CITY OF ALBUQUERQUE

August 29, 2024

**Re: Speedway at Juan Tabo
2932 Juan Tabo Blvd. NE
30-Day Temporary Certificate of Occupancy
Transportation Development Final Inspection
Engineer's Stamp dated 06-19-23 (H22-D041)
Certification dated 08-26-24**

STORE OR BLDG NO.	9244	
VERSION OR PROJECT ID	119405	
SCALE	1" = 20'-0"	
DESIGN TEAM	DATE	
DGNR.	EPS GROUP	6/27/2023
P.MGR.	T. YOUNG	6/27/2023
RWR.	A. BARKER	6/27/2023
DRWG. NO.	CS2

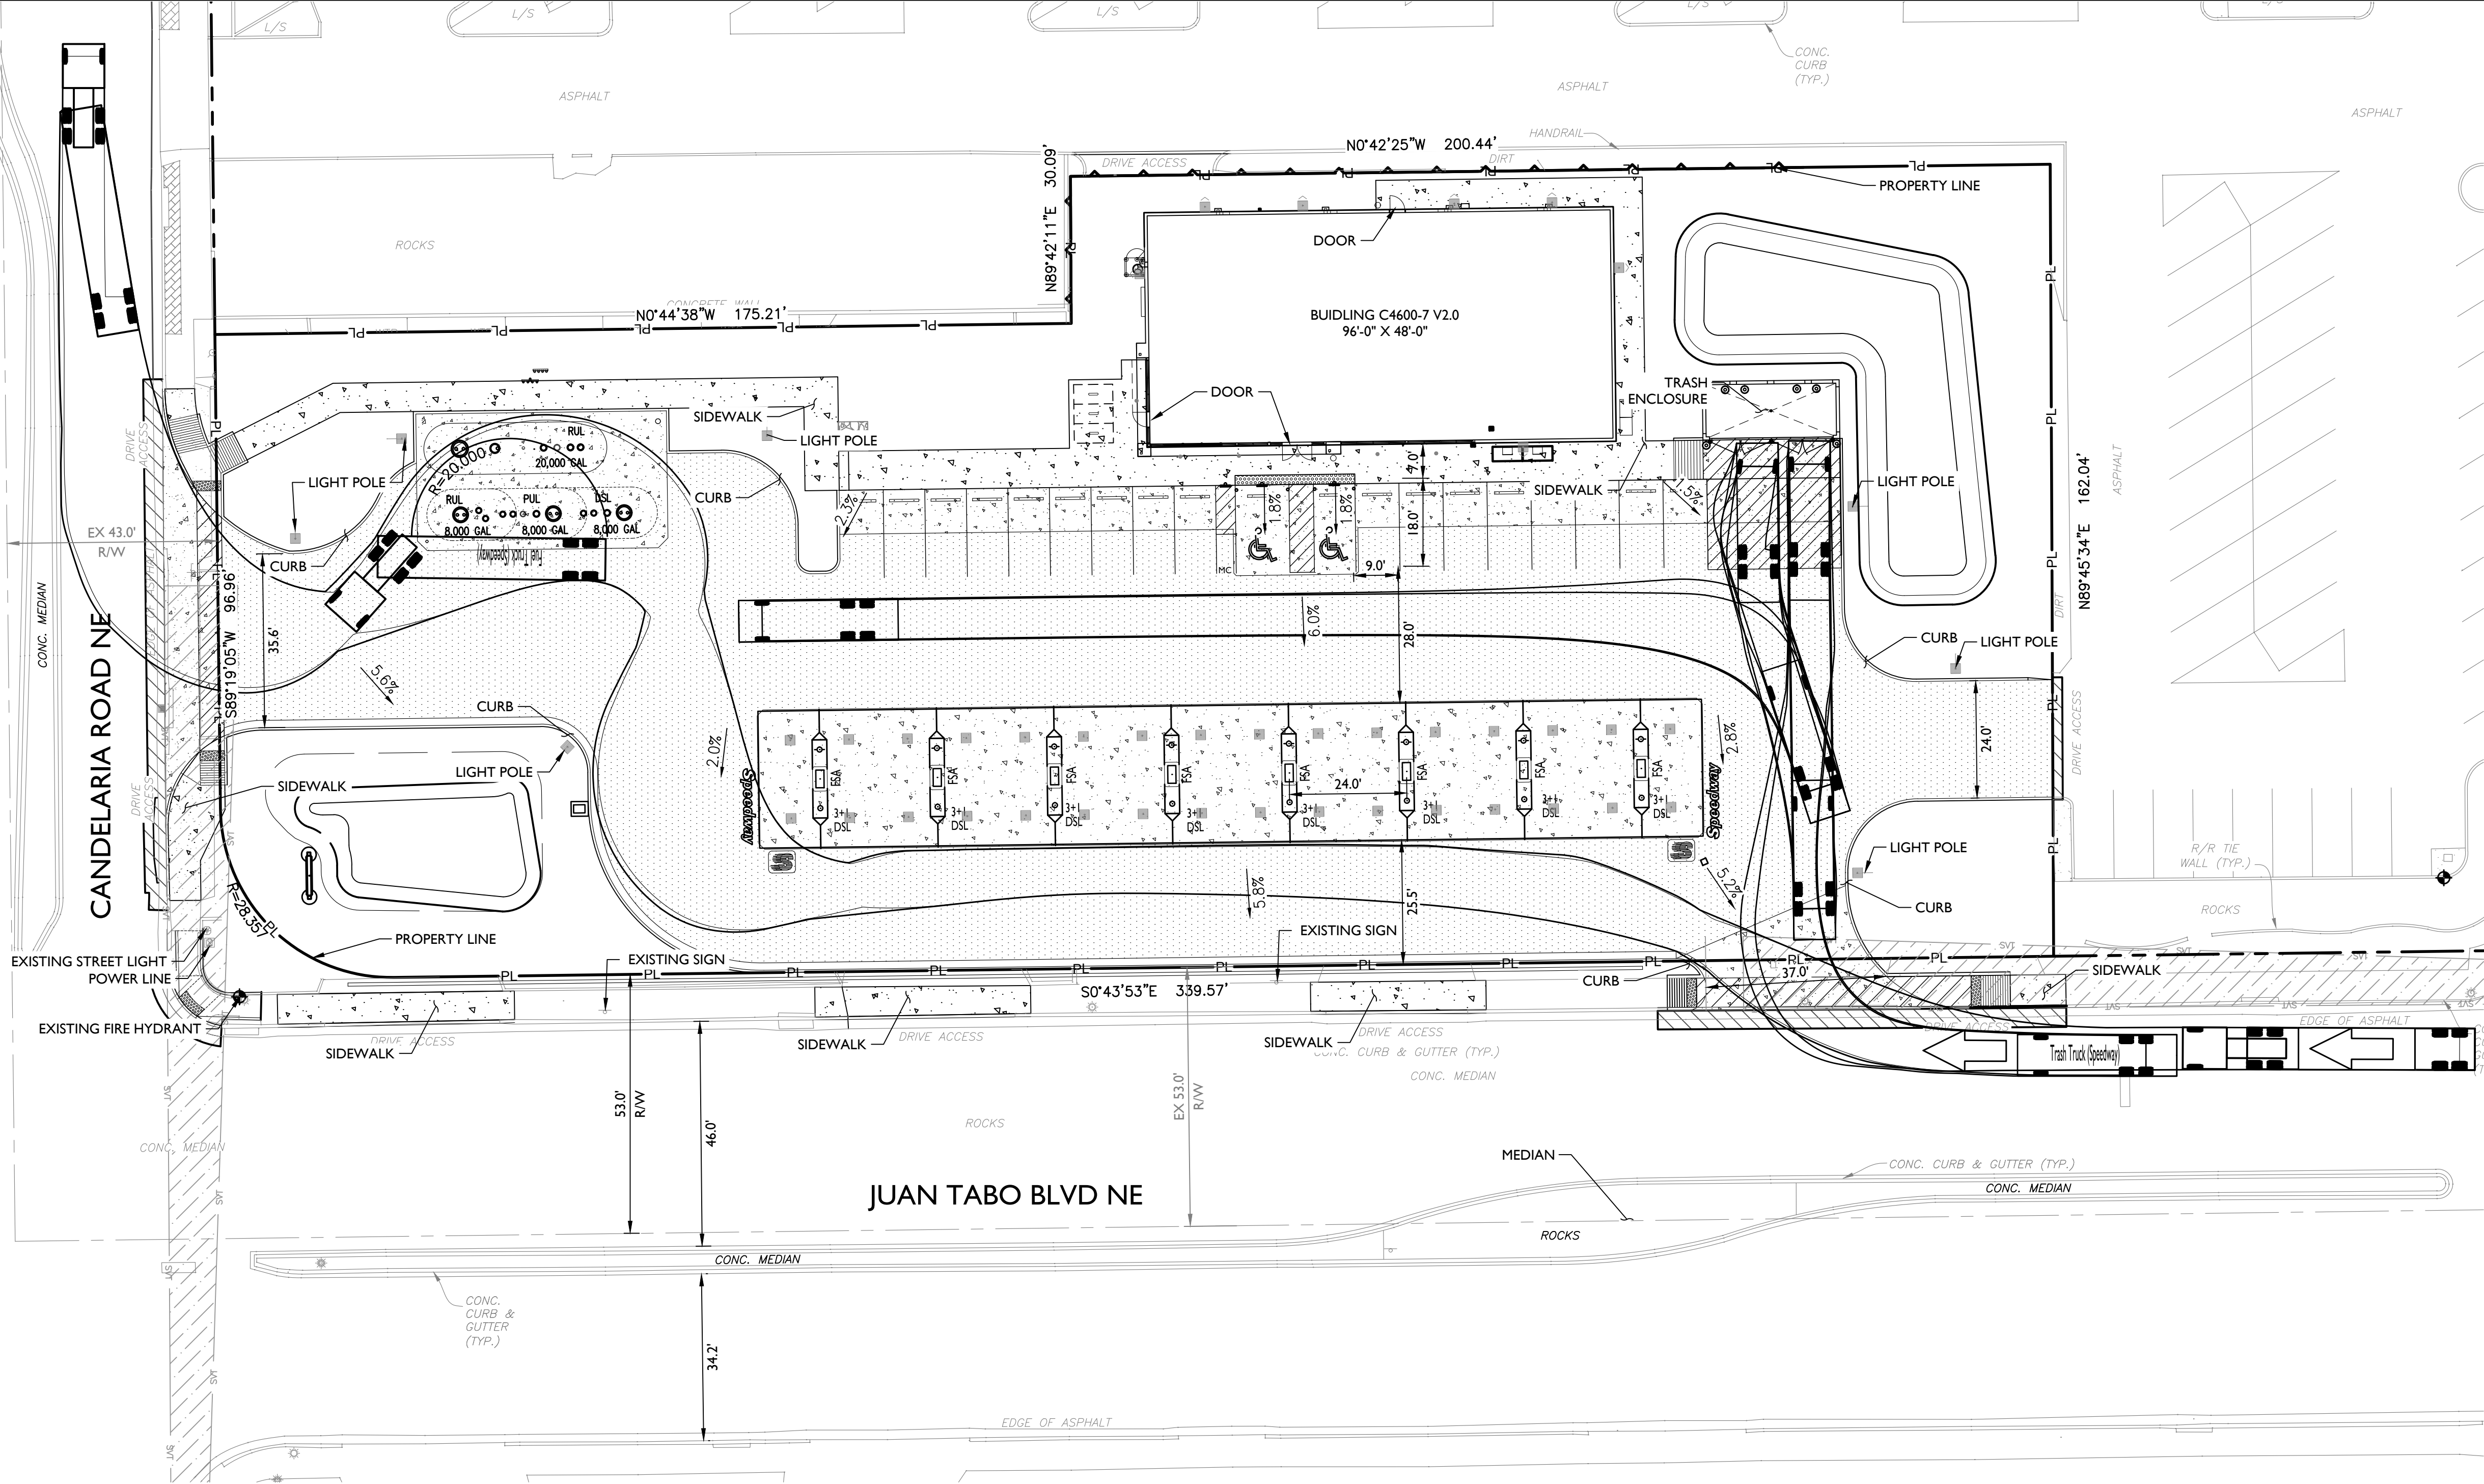
- Per approved site plan, ADA curb ramp at the corner of Juan Tabo Blvd. and Candelaria Rd must be updated to the current ADA standard and has Truncated Domes installed.

- Per the site visit, the running slope for the ADA ramp at the site access off Juan Tabo Blvd. was 8.8%, the maximum running slope should be 8.3%, 7% preferred slope. Please provide ADA ramp meets the city standard.
- Per approved site plan, AN APPROVED ACCESS EASEMENT IS A CONDITION OF THE RELEASE FINAL CO.
- Anchor down bike rack.
- Provide Motorcycle parking sign.
- Please provide a "VAN" sign for the ADA parking space.
